16 March 2016

PROPERTY: LOT 21 DP 1171076, 14-54 DENNISTOUN AVENUE, YENNORA
SUBJECT: MODIFICATION REQUEST

Thank you for the opportunity to comment on the Yennora Distribution Park – Modification request.

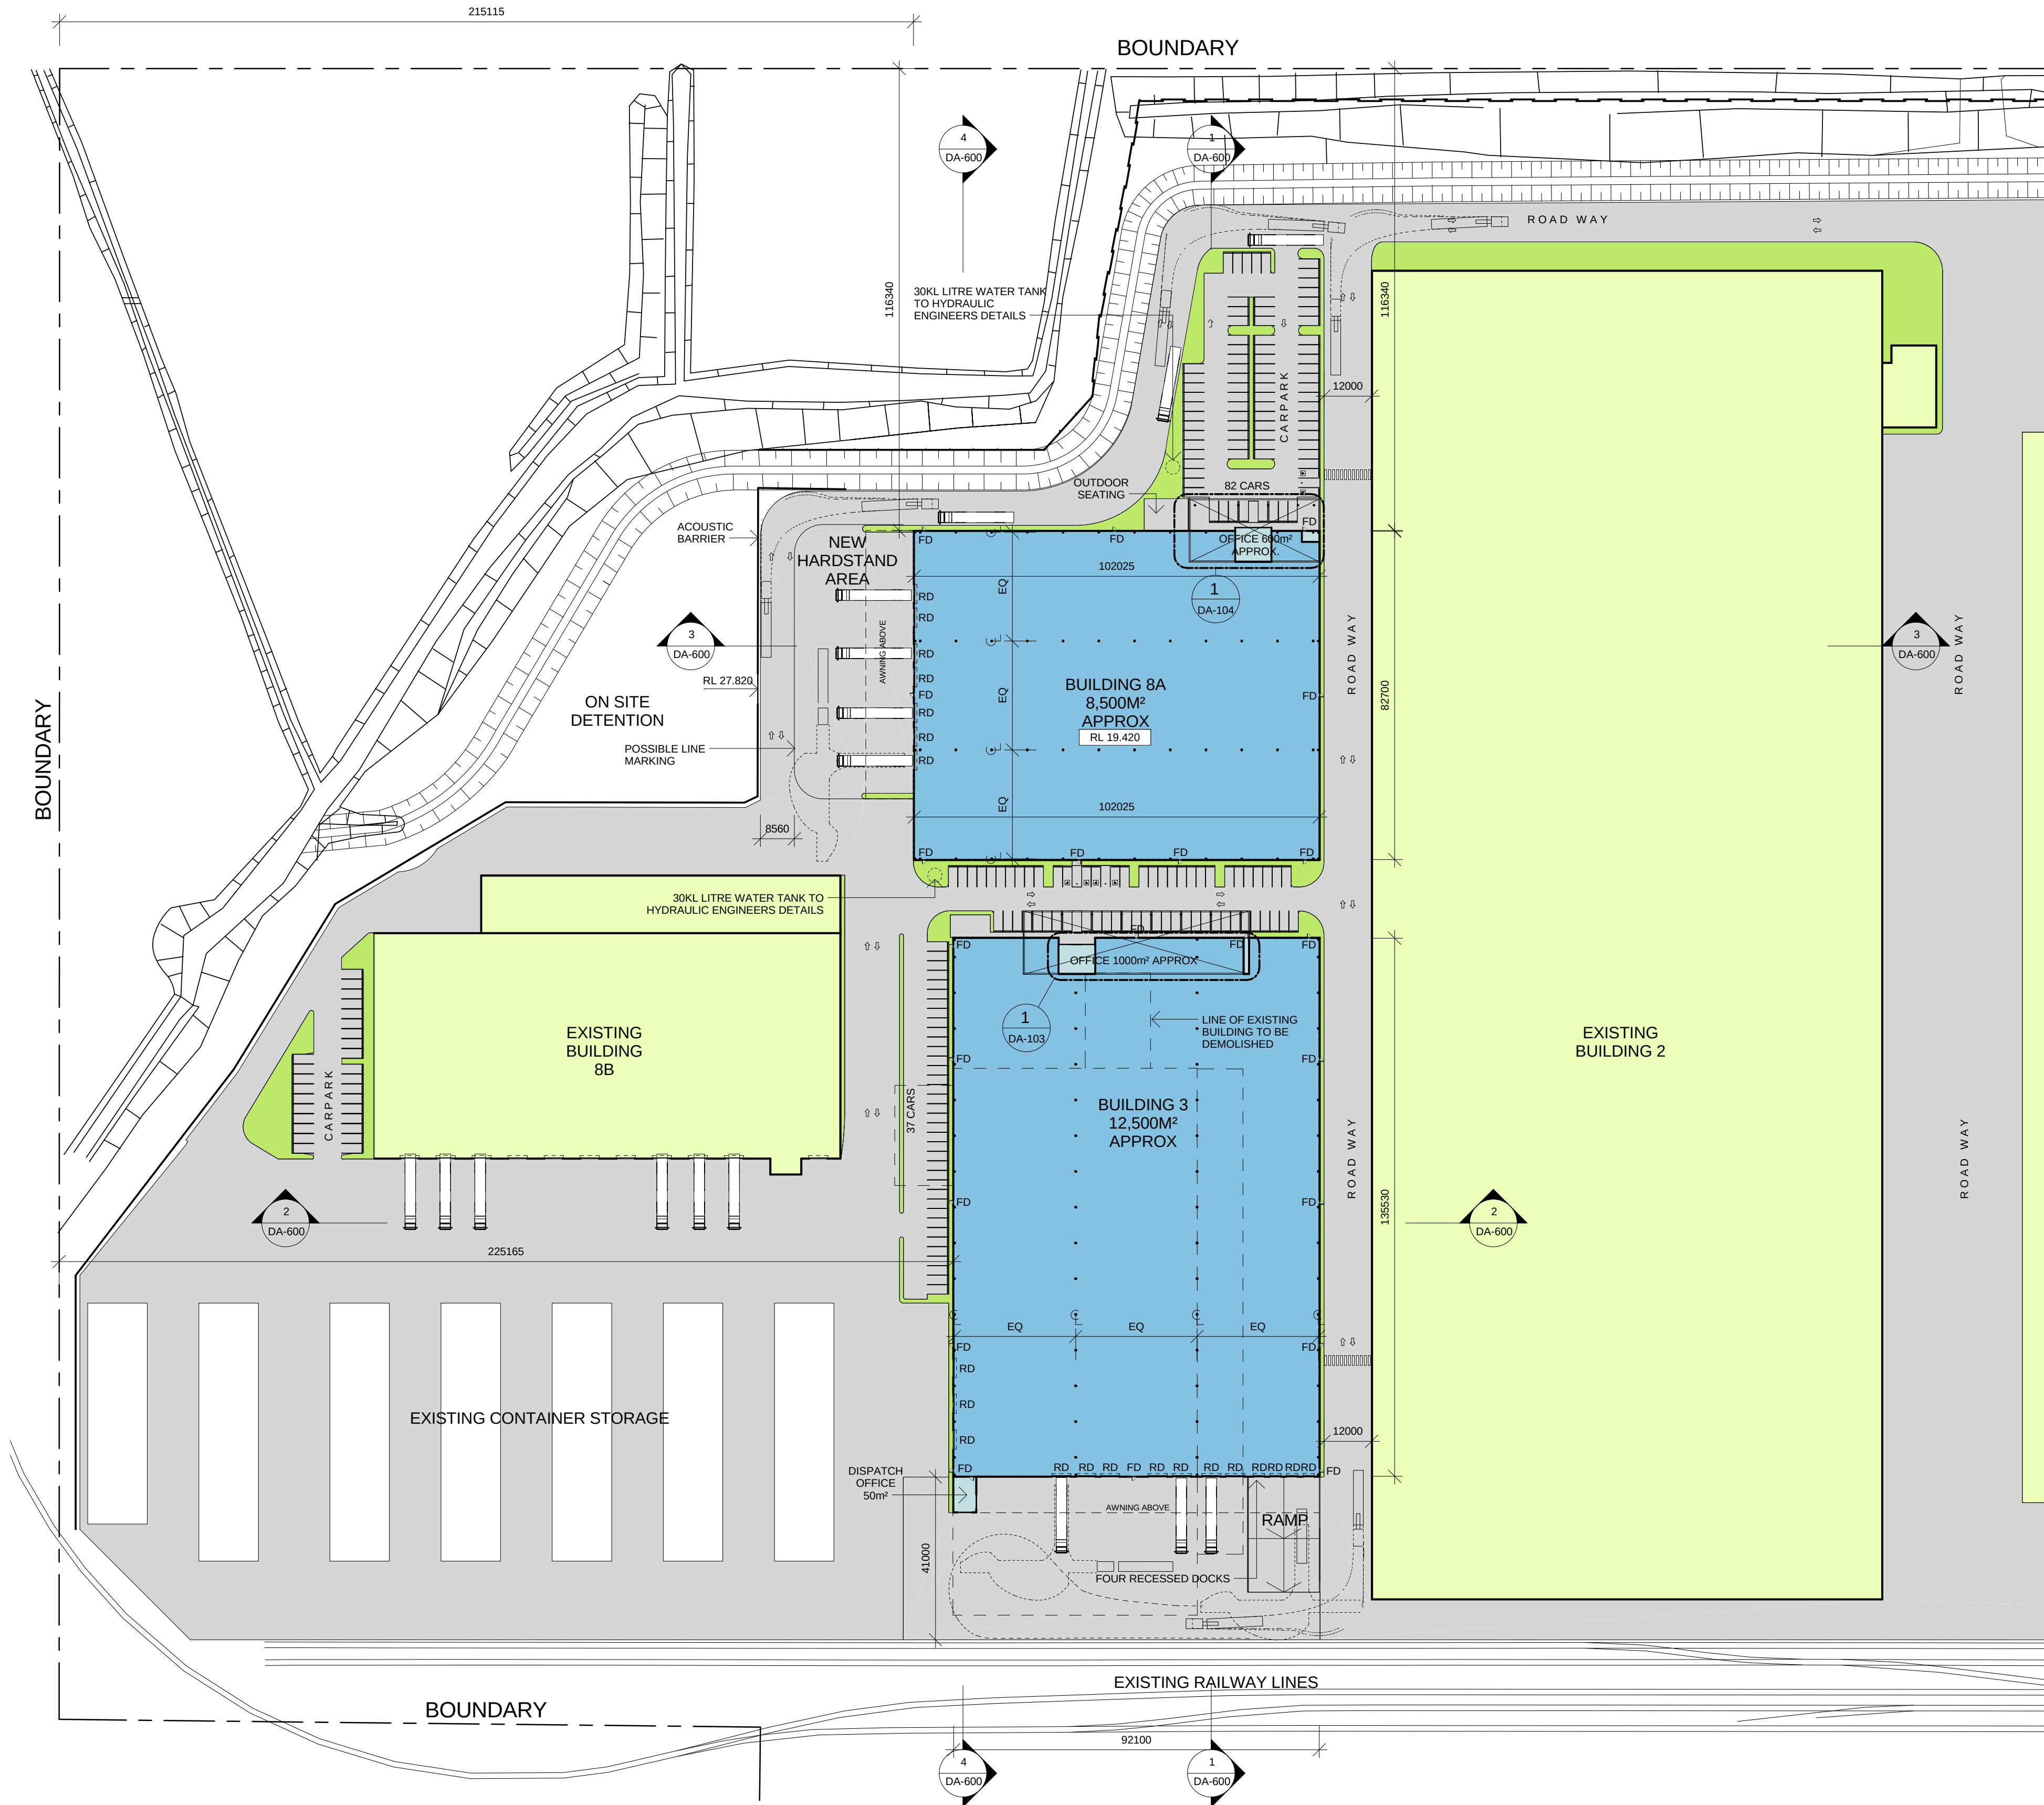
1. Car parking spaces located north of building 8A shall be provided with at least 300 mm clear of obstructions higher than 150 mm such as walls, fences and columns in accordance with AS 2890.1:2004.

2. The gradient of the ramp for the loading bay located south of building 3 shall be shown on the plans. The gradient of the ramp shall be in accordance with AS 2890.2:2002.

1 BUILDING 8A PLANTING PLAN
1 : 500

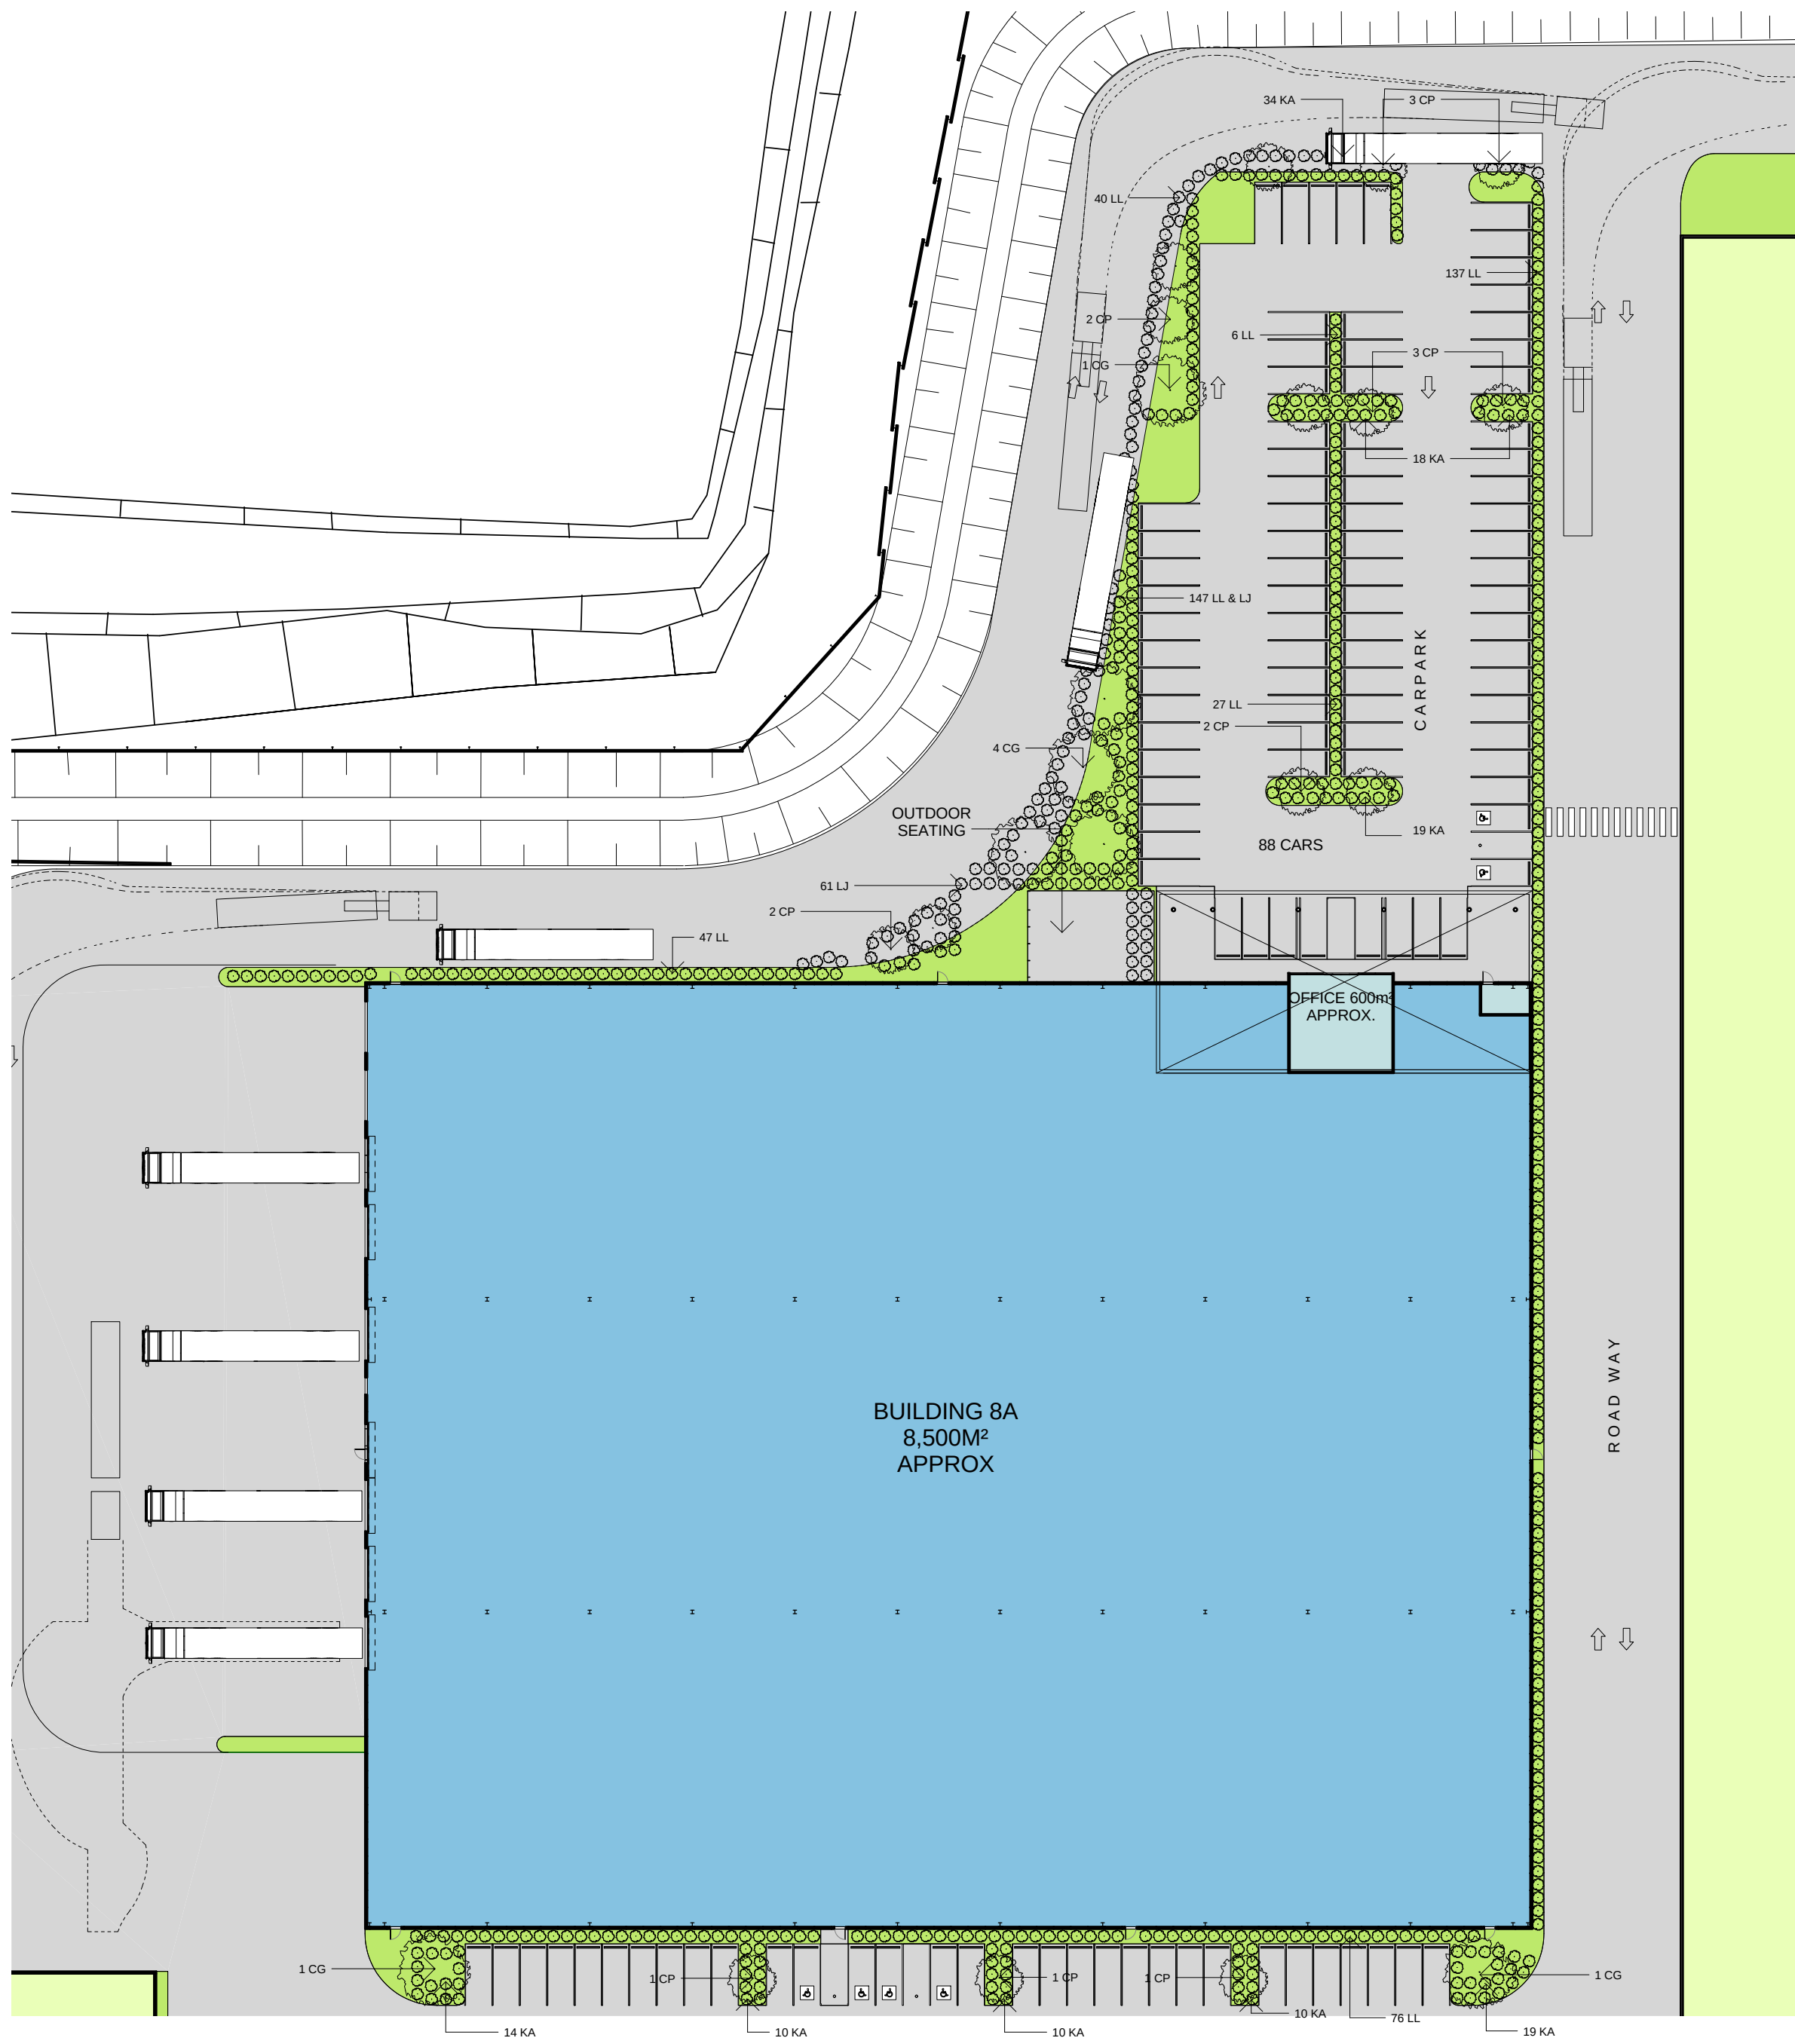
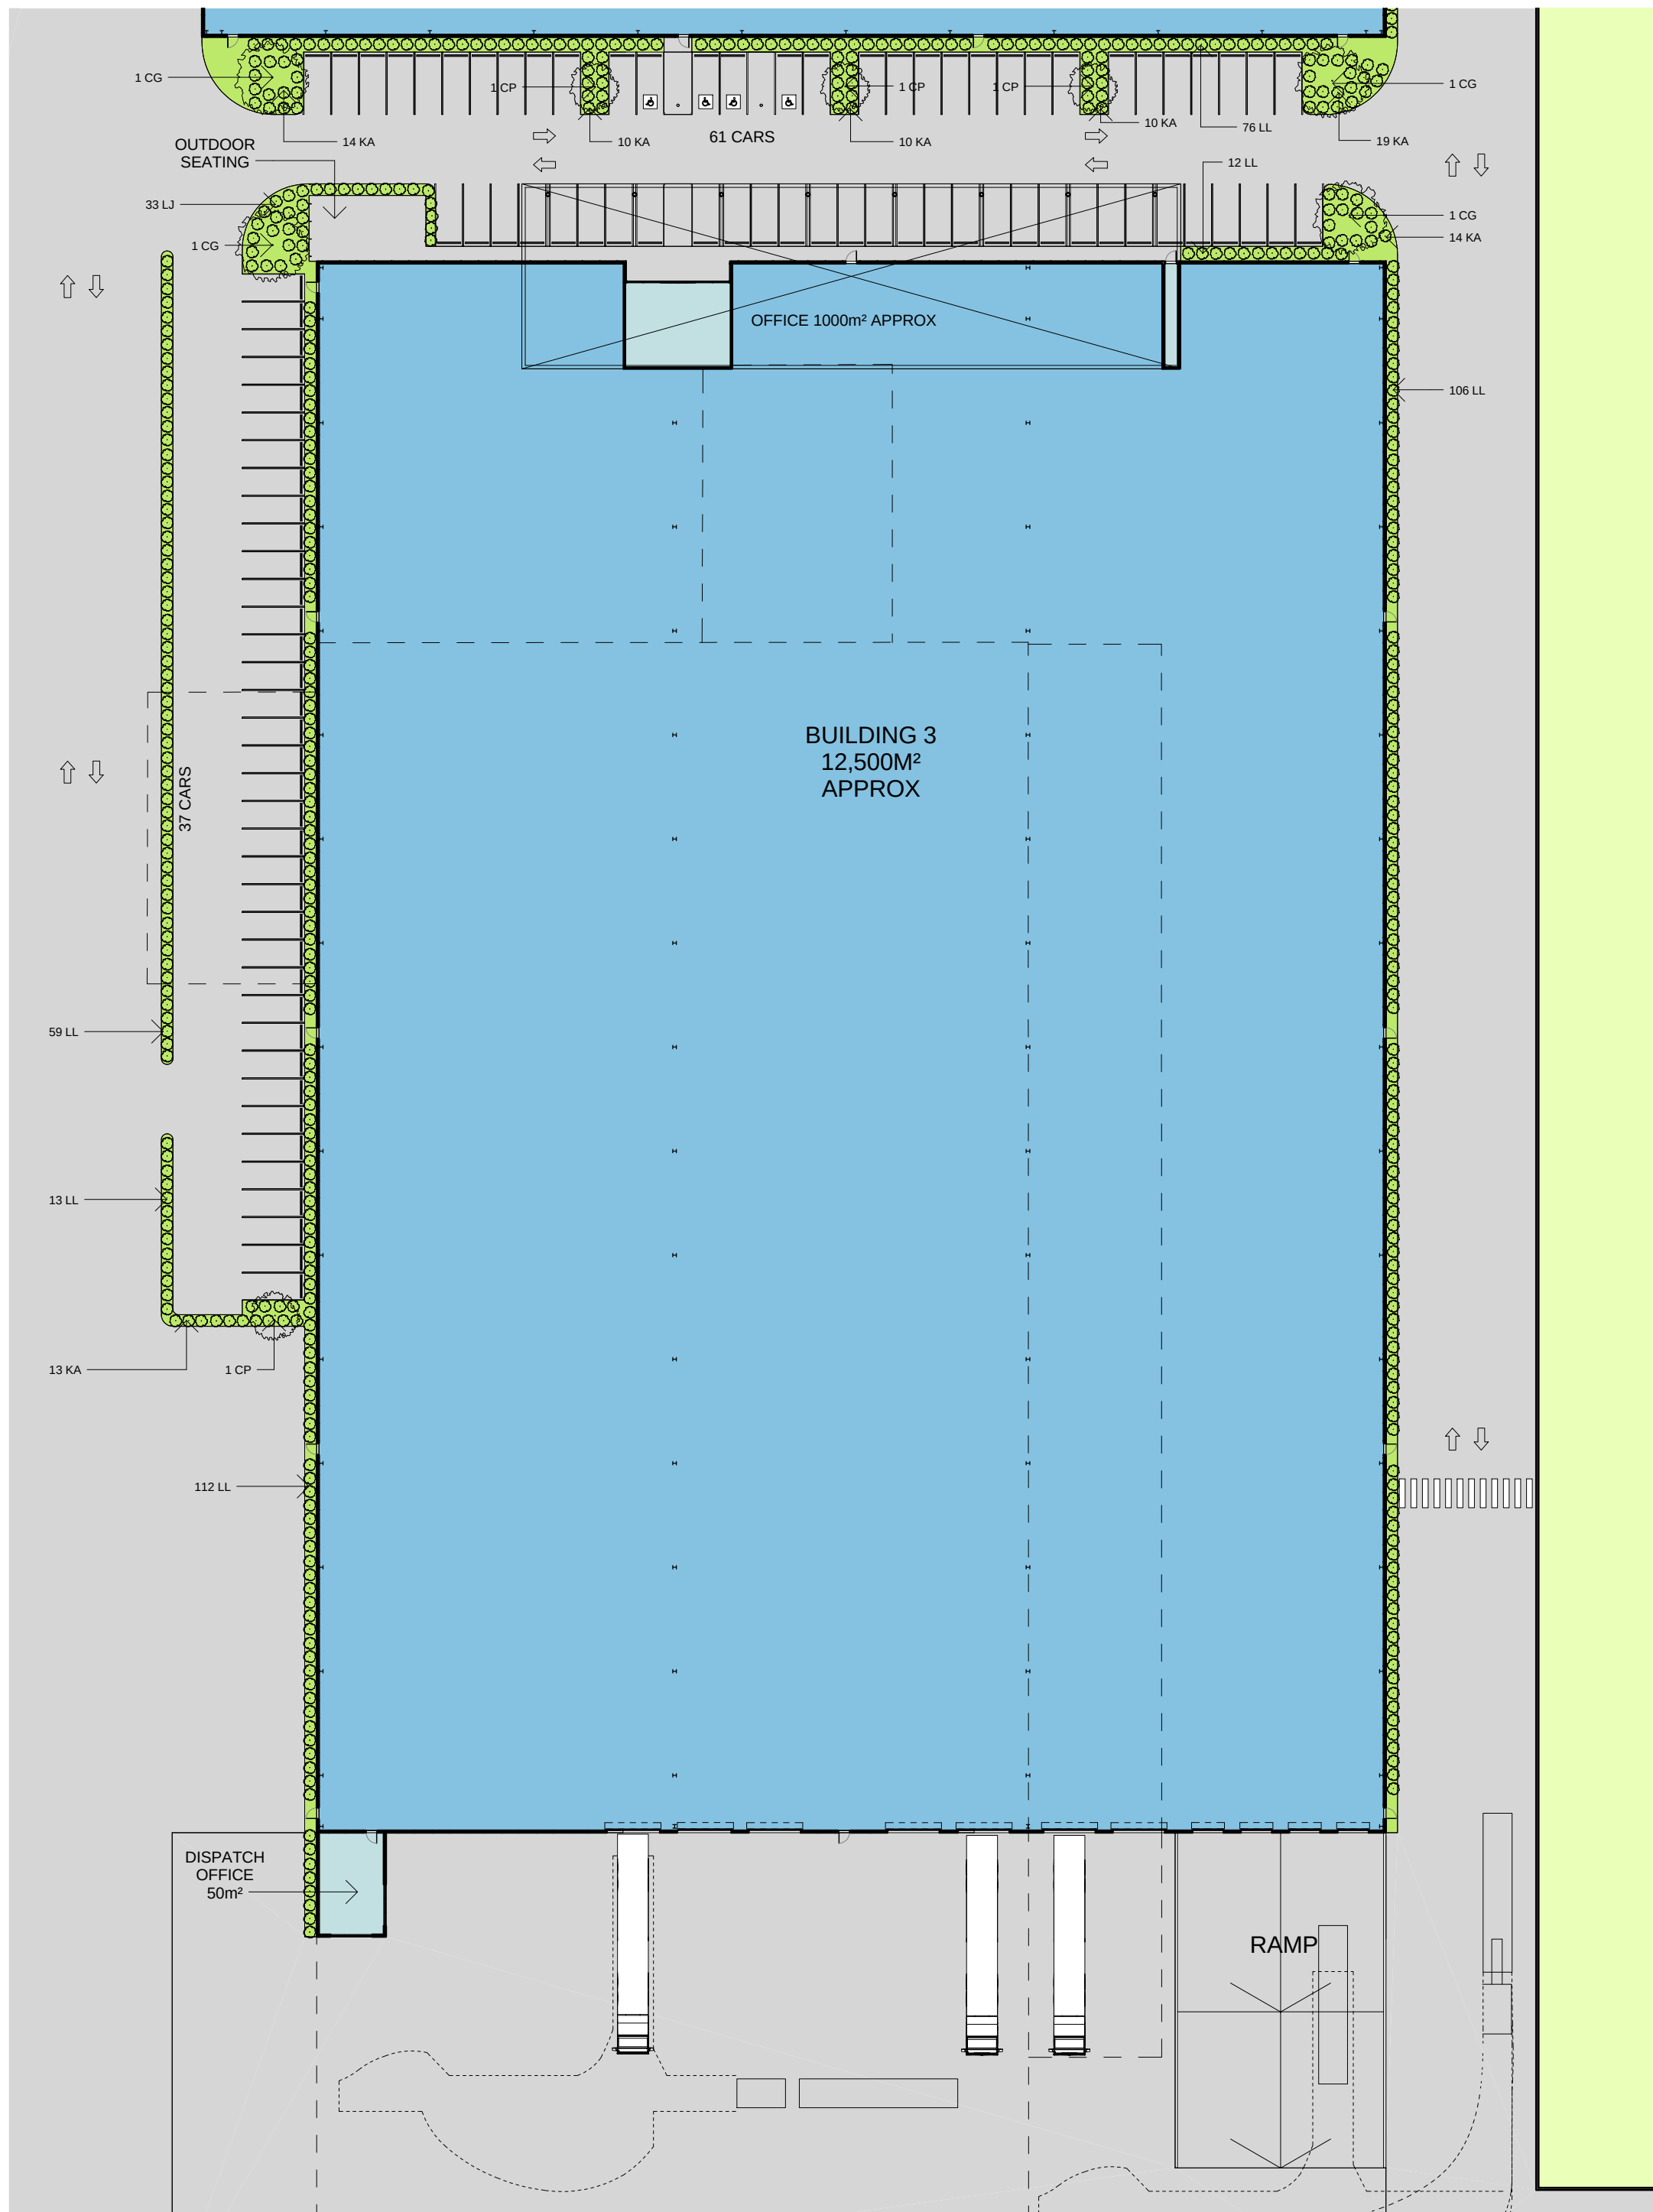
1. Amended architectural, engineering and landscape plans are to provide for the required tree planting bays within the car park areas as per DCP Part A, Clause 3.4, c7 and figures 8, 9 and 10 on page 36.
2. Submission of a fully documented landscape plan prepared by a qualified landscape architect and which provides for:
 - a. Native plant species selected from the Yennora Distribution Park plant species list **(copy attached)**
 - b. Car parking areas shall provide a native tree planted every 5 spaces, to be planted in the required planter beds as per item 1 above.
